Our Ref: FP/275/18/HH

**Town & Country Planning Act 1990 (as amended)
Town & country Planning (Development Management Procedure) (England) Order 2015
Application for Planning Permission for Works or Extension to a Dwelling**

Development Double storey side/rear extension, remodelled roof and modified vehicular access and landscaping

Location 20 Wedgwood Road Felpham

Proposed Floor Plans

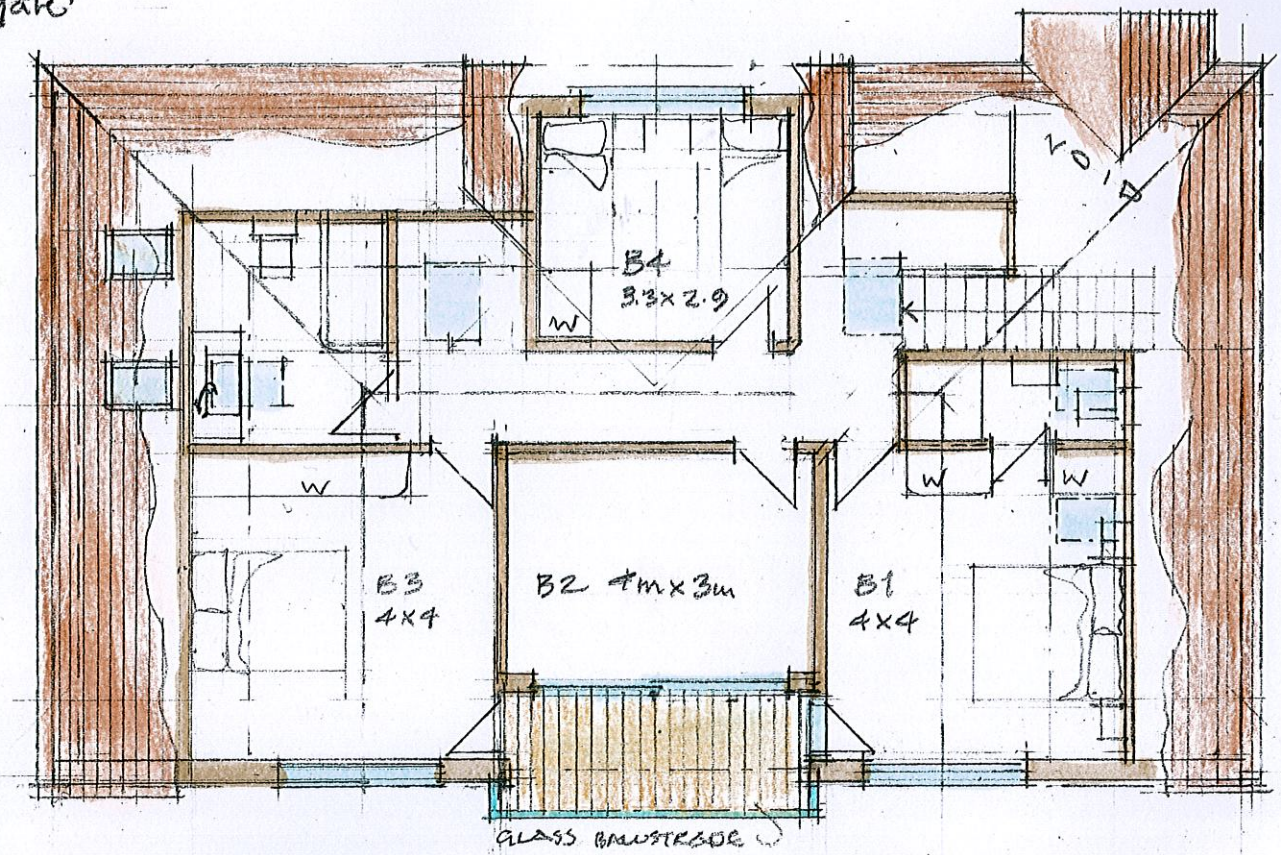
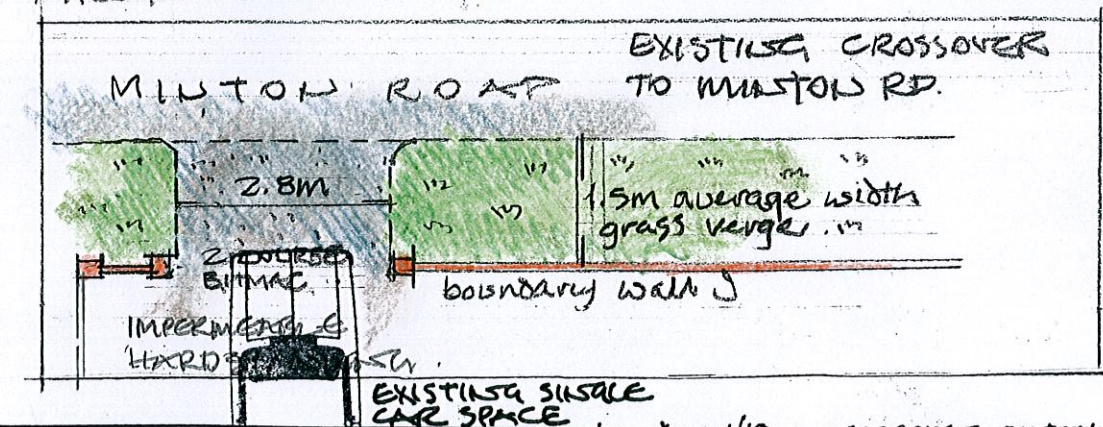
Crossover: Please can you add dimensions to the proposed crossover and provide us with an existing crossover plan.

Parking: You are required to show the proposed parking on your plan.
